ADC PARKS & GREENSPACE ARBORICULTURE CONSULTATION

PLANNING APPLICATION: **R/190/12/T**

ADDRESS: Knightscroft House Sea Lane Rustington BN16 2RT

BRIEF DESCRIPTION: Fell 1no. Sycamore tree & fell left hand 'fork' on Sycamore tree

TREES WITHIN THE GROUNDS OF KNIGHTSCROFT HOUSE,
SEA LAKE, BUSTINGTON. TREE PRESERVATION ORDER No.1/1976/A

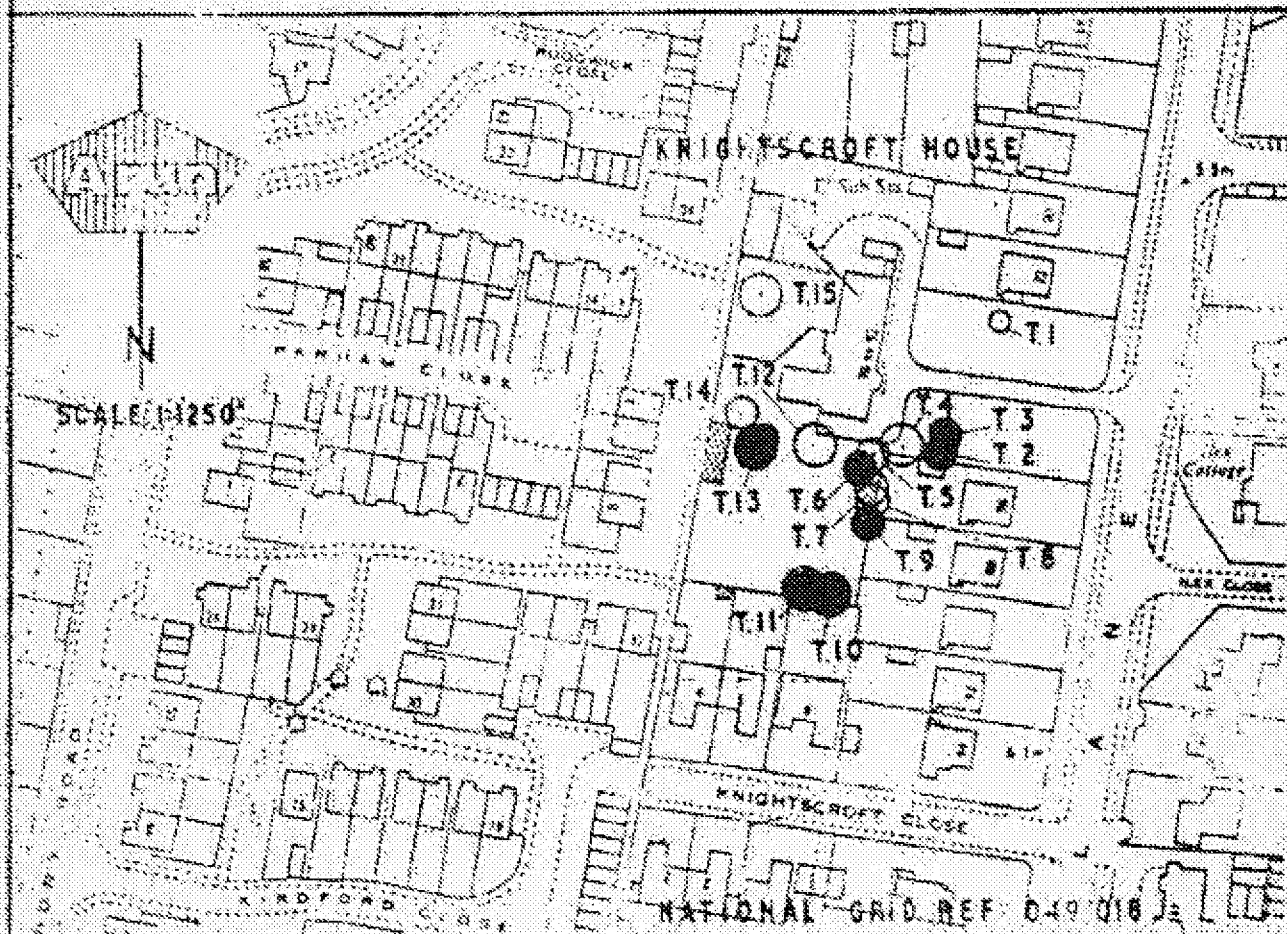
- 1) Multiple growths of approximately 3-4m in length emerging from the pollard points found in the upper crowns of T7, T8 and T15 must not be cut below these swollen 'knuckle' points of origin.

- 4) The removal of the remaining lateral branch growths must not exceed 3m lengths all around the periphery of T15 and for the south portion of T7 where they grow towards the bungalow No.5/6.
